Answers to Inspector's questions

As part of the DCO process for the Highways England proposal of developing the M4 into a Smart Motorway between junctions 3 to 12 the Inspector has issued a series of 1st round questions. The following are the answers to those that SBDC feel are relevant to the issues concerning the district as a consequence of the scheme.

Drawing title  
SIDE ROAD PLAN & PROFILE  
REGULATION 4(2) (e)  
SHEET 13 OF 13  
OLD SLADE LANE

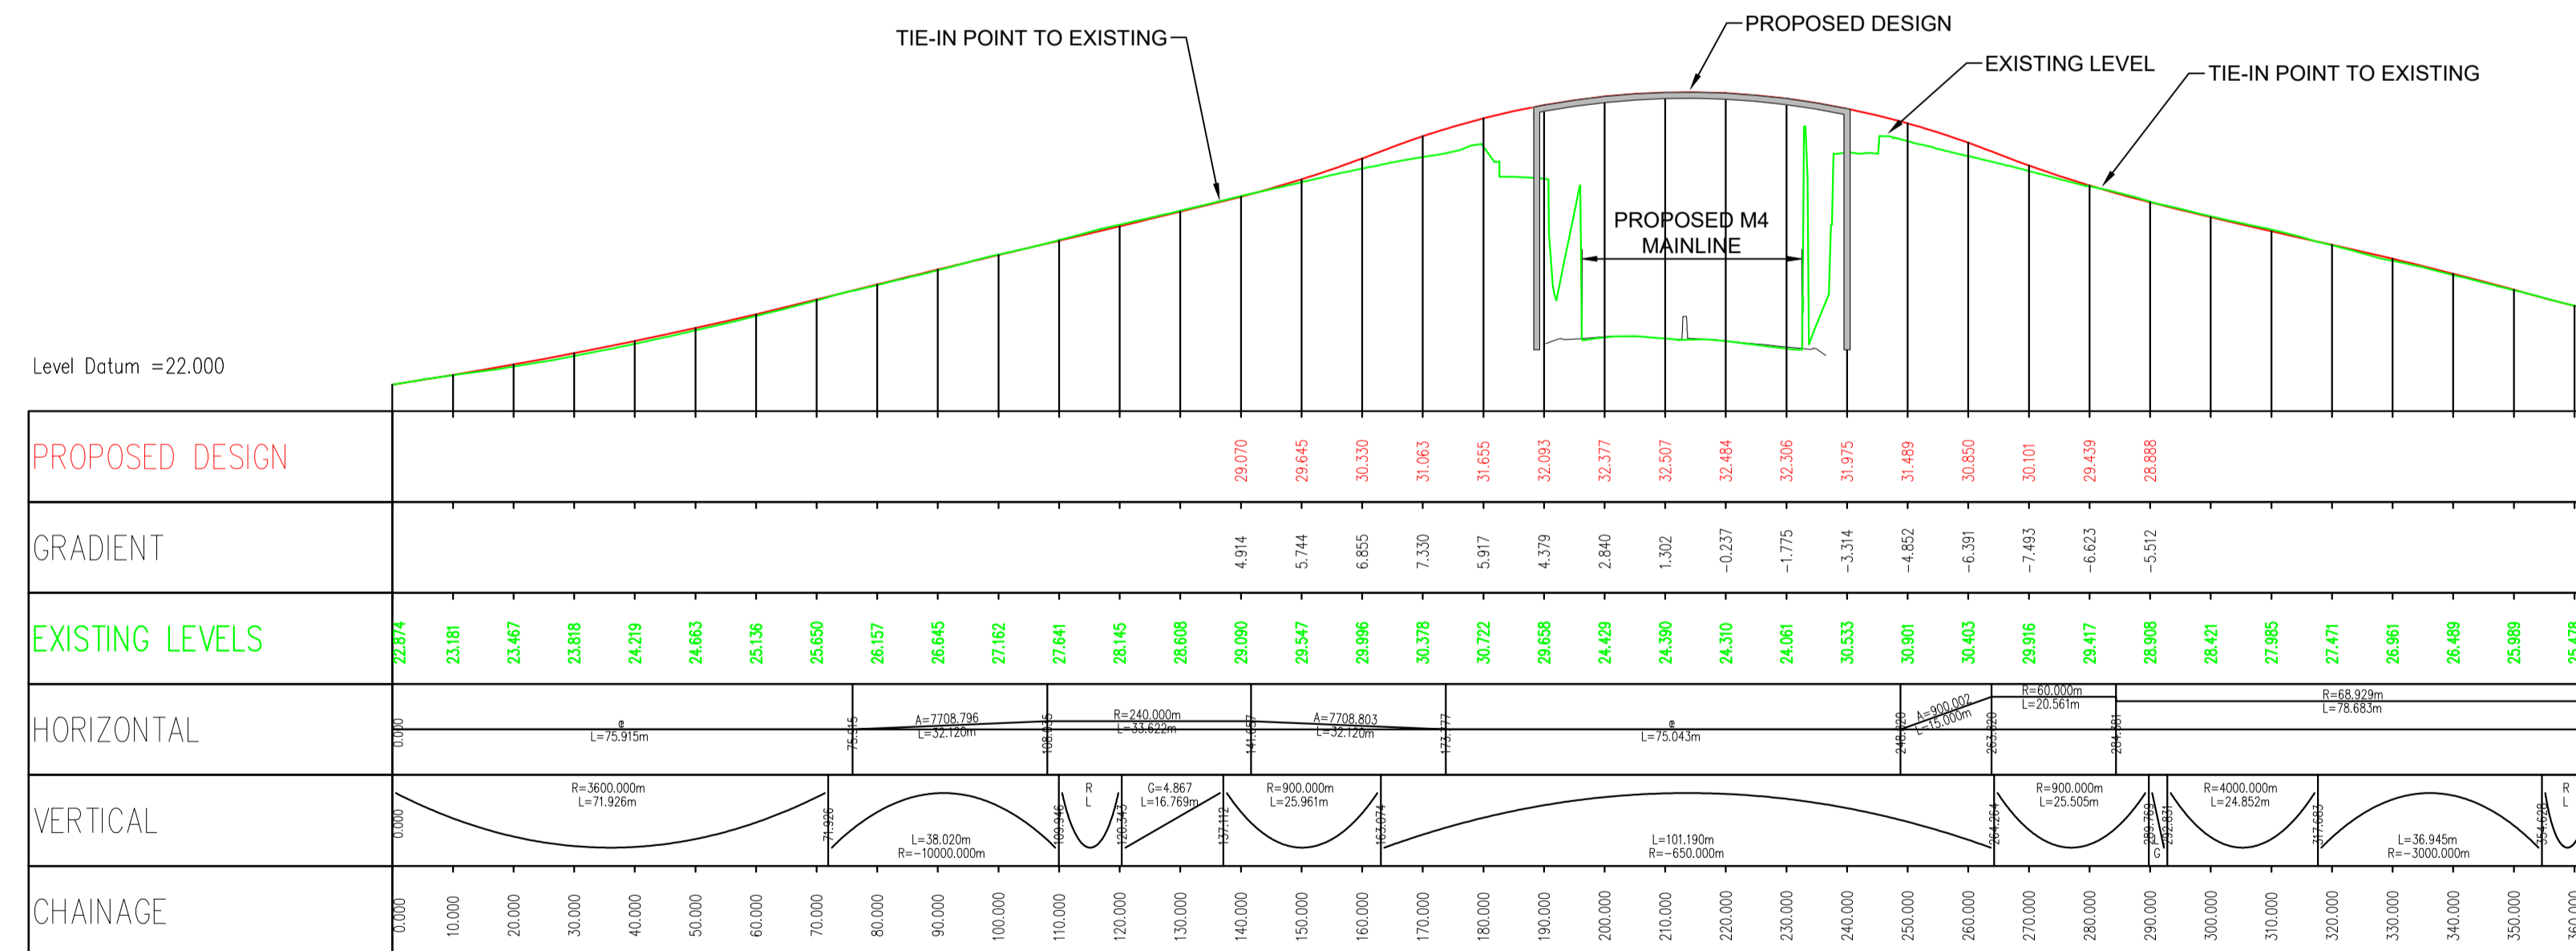
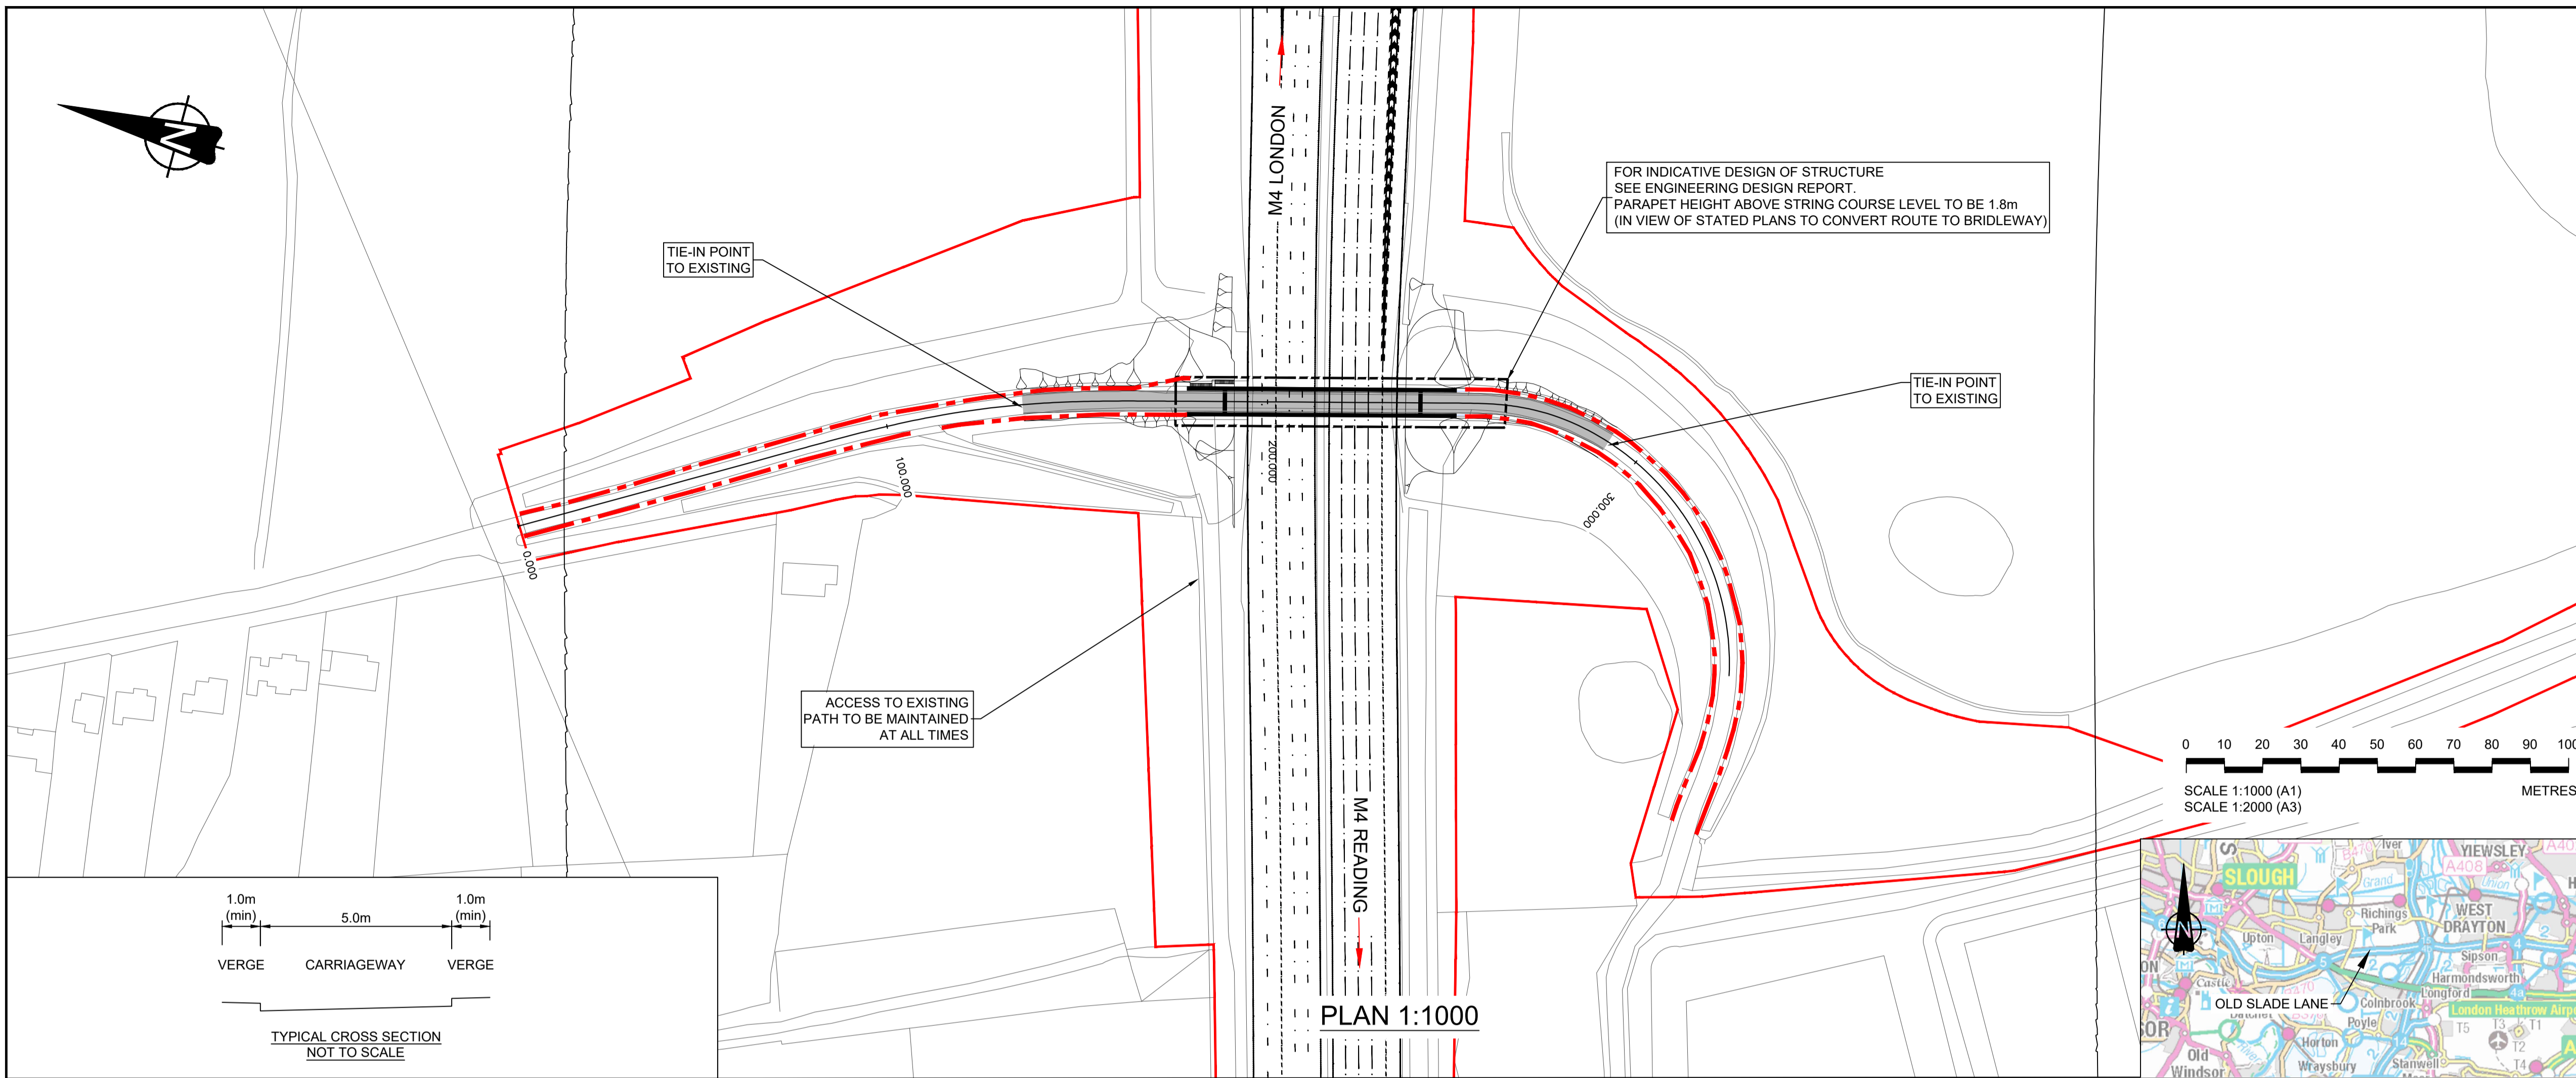
2.4	No it is not compatible with local strategies designed to promote sustainable transport. There will be a negative impact on the cycle and walking network within the Colne Valley Park as a result of the proposed year long closure of the bridge at Old Slade Lane and also there will be a possible impact on the Thames Path national trail and Jubilee River rights of way during the construction of bridges in Dorney.

5.	Highways-related issues in South Bucks are dealt with by Buckinghamshire County Council
5.7	At present the proposal for rebuilding the bridge along Old Slade Lane is still not agreed. The Council supports the Colne Valley CIC's stance with the closure of the bridge causing a major disruption to one of the main footpath and cycleways in the park.
